# ESC Violations at Buglo Apartments 5330 Buglo Ave NW

By Doug Hughes SWQ Principal Engineer for the City of Albuquerque

History and Justification of (\$8,000) fines on City Project B11E013, EPA ID NMR1003YA

**Re: Buglo Apartments - 5530 Buglo Ave NW**  
**Erosion and Sediment Control Plan**  
**Engineer's Stamp Date 5/26/2021 (K19E108)**

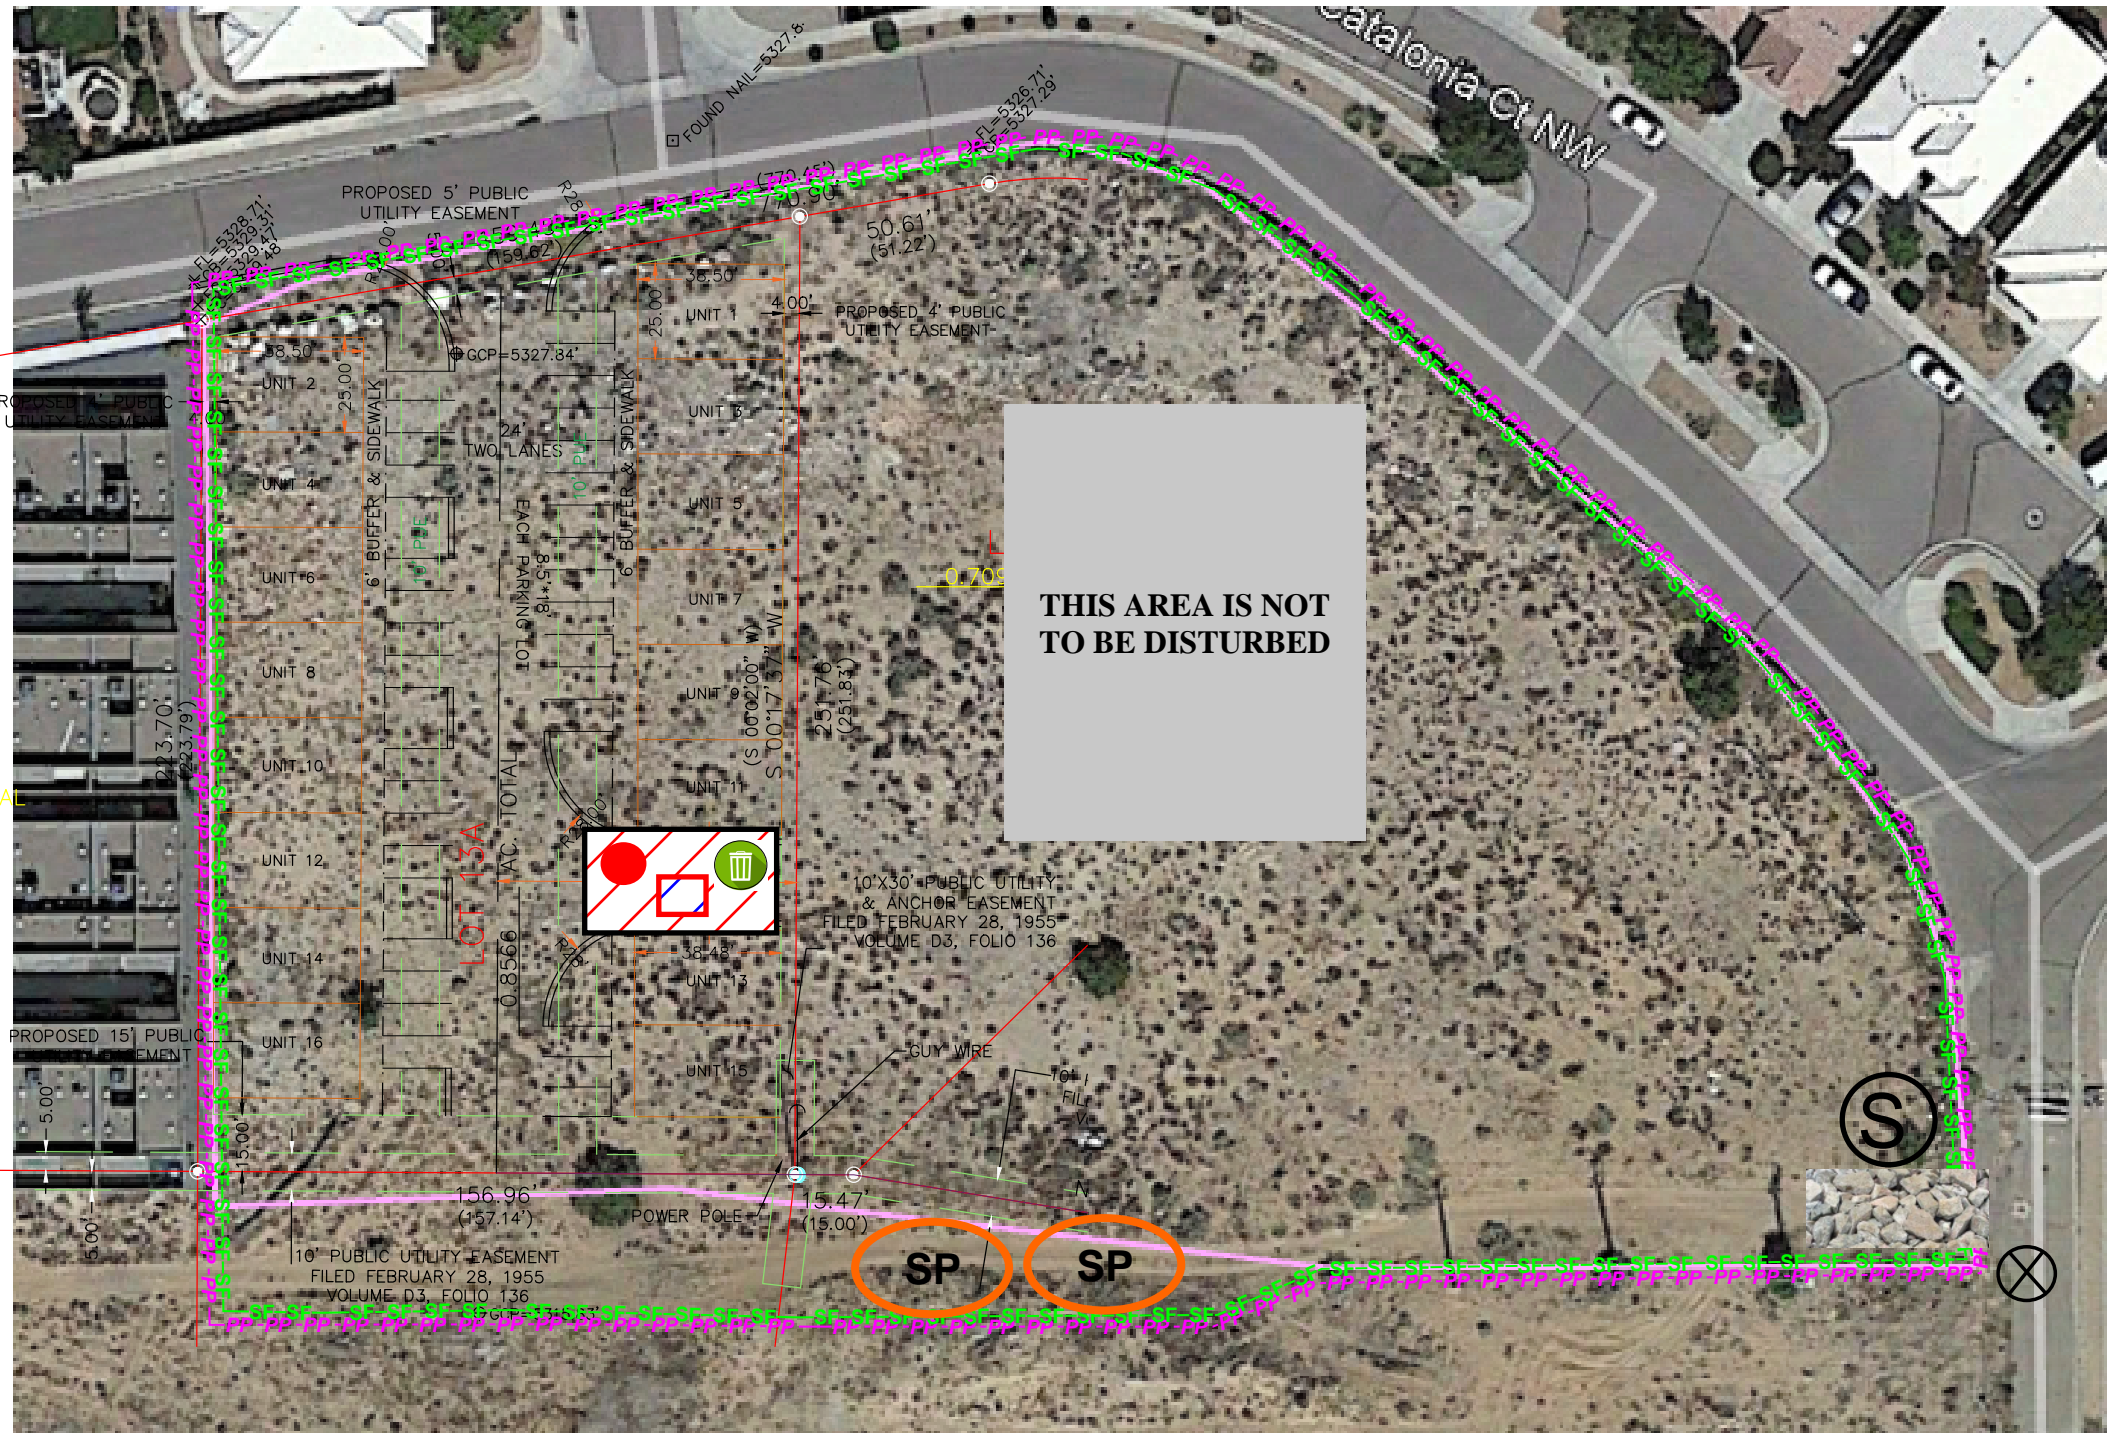
1. The plan must be updated using the approved G&D Plan as a base. The existing and proposed grades must be shown on the plan. (CGP7.2.4.b.ii);
2. The limits of disturbance must be shown and include the disturbance on the adjacent properties. Show the staging and stockpile areas adjacent to the proposed apartments.

STABILIZATION PLAN

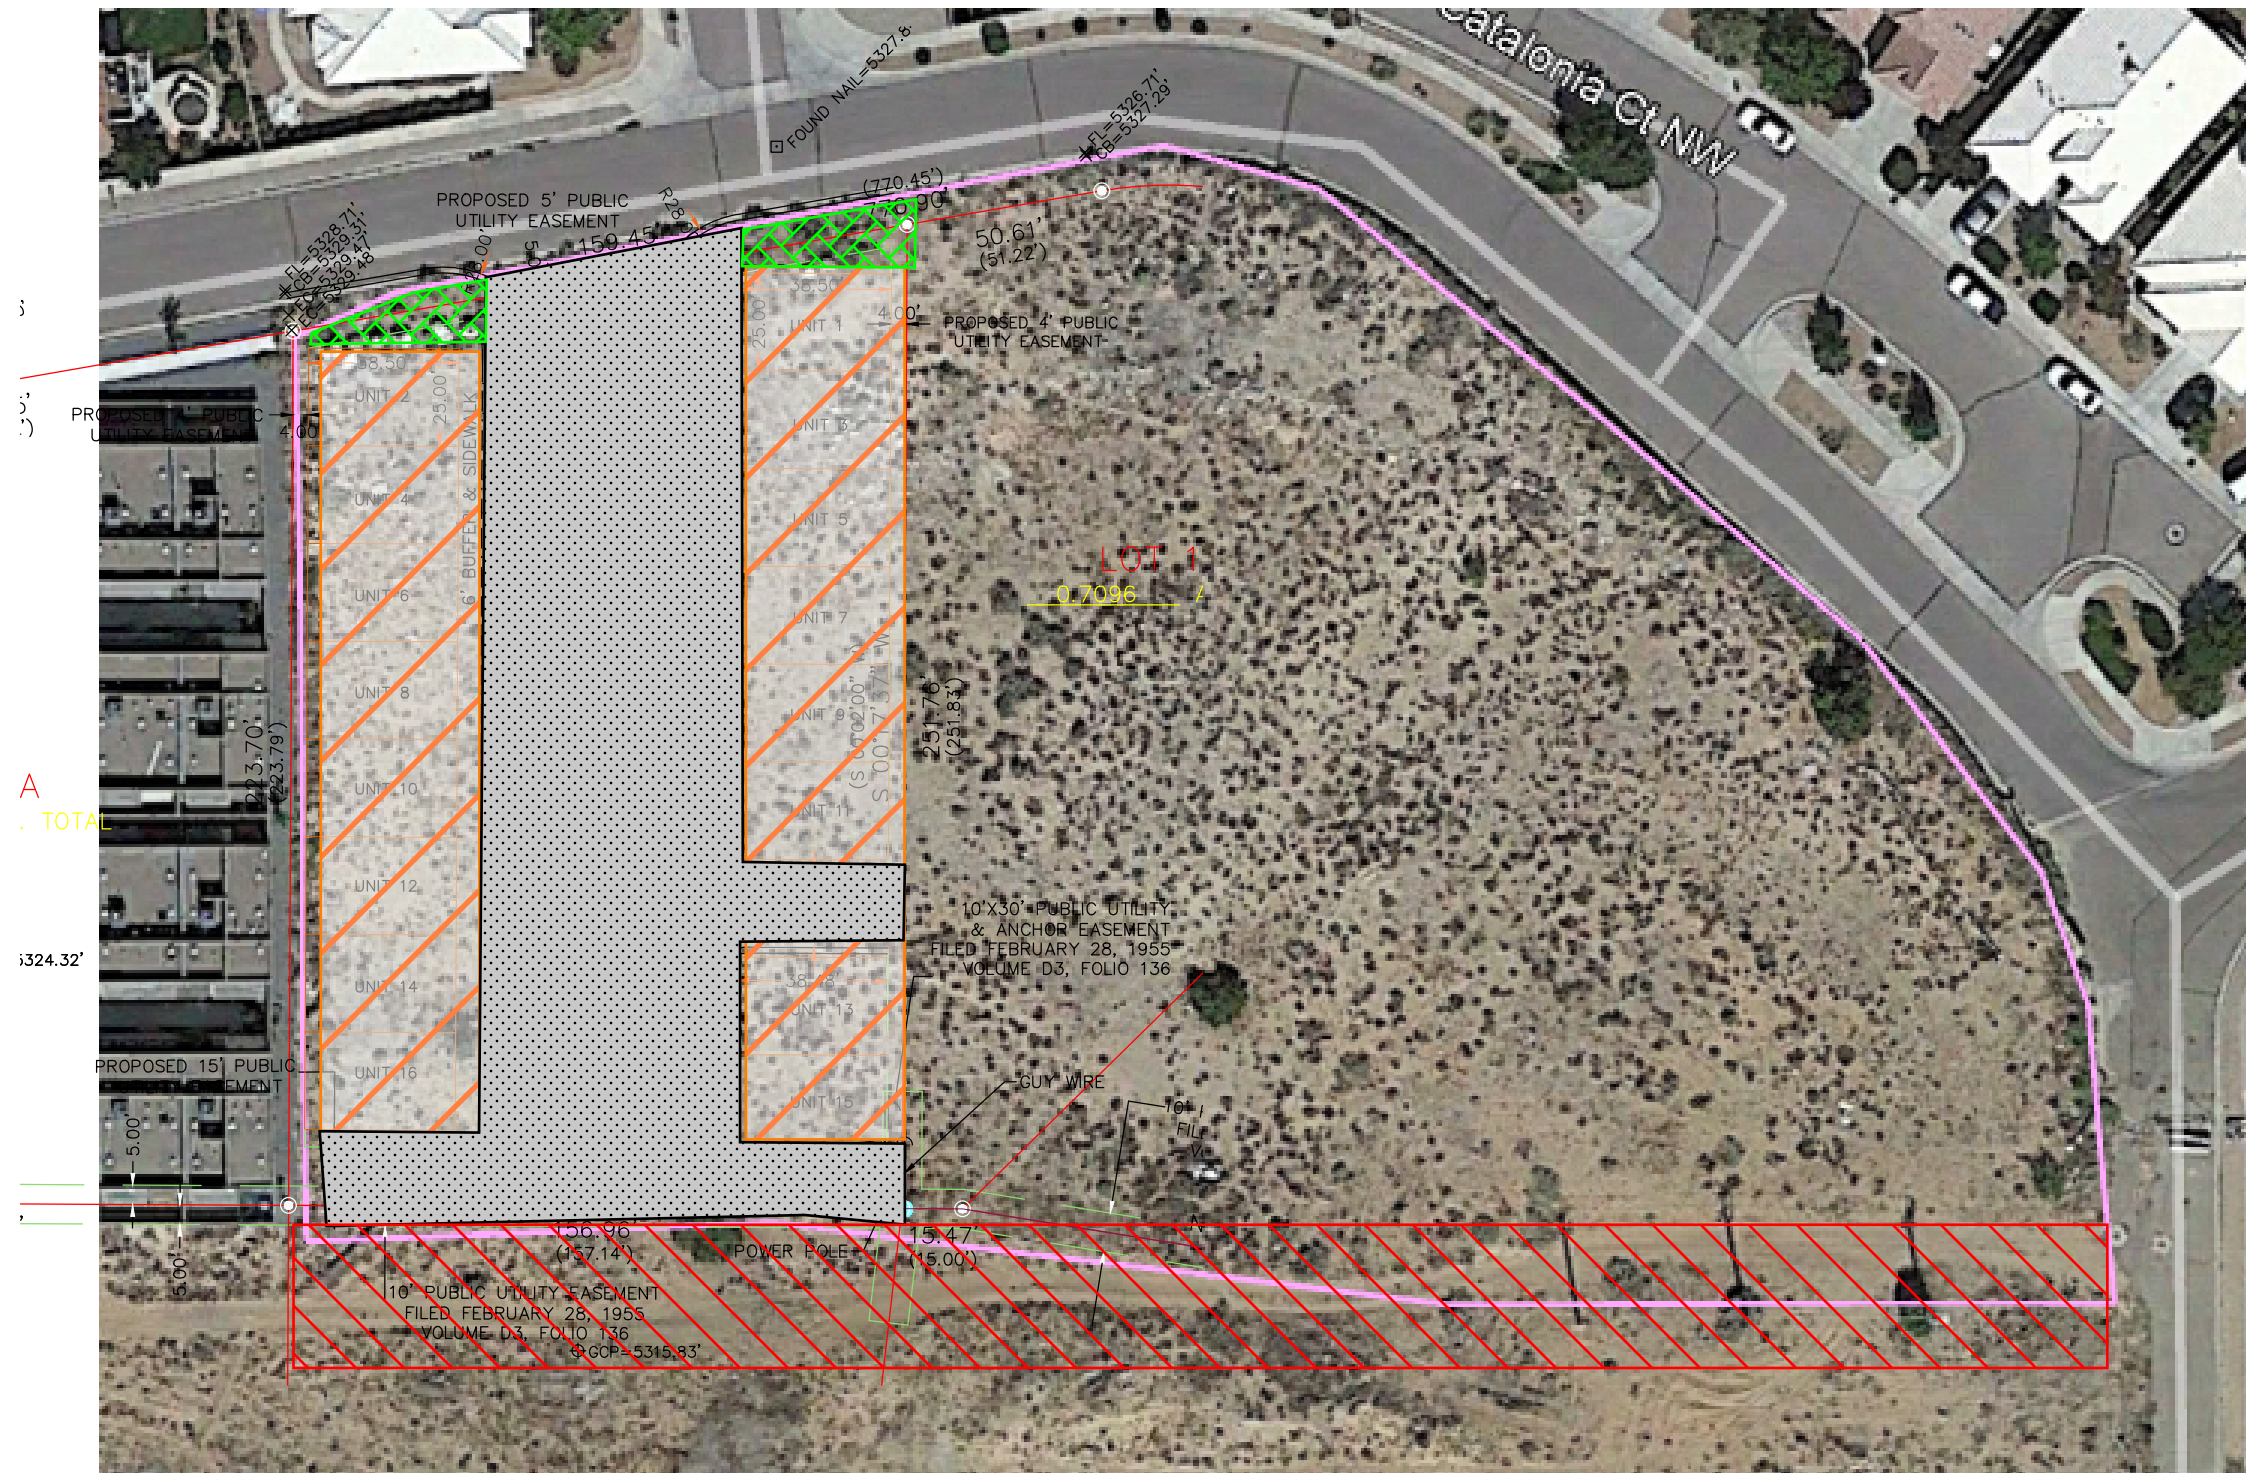
3. Identify Final Stabilization measures for those and include specifications such as Native Seed and Aggregate Mulch per City Standard Specification 1012. The Hydromulch shown on sheet 5 doesn't satisfy the Final Stabilization Criteria.

4. Describe undisturbed and pre-construction ground cover, including the percentage of ground cover. (CGP7.2.4.e);
5. Describe the nature and extent of construction activities for each operator (CGP 7.2.2.), including a) nature of construction activities, b) size of the properties, c) size of disturbed area, d) description of construction support activities, e) size of maximum disturbed area, and f) Project Schedule including temporary stabilization of inactive areas, and final stabilization of off-site areas adjacent to the apartments. The hydro-mulch shown is a temporary measure
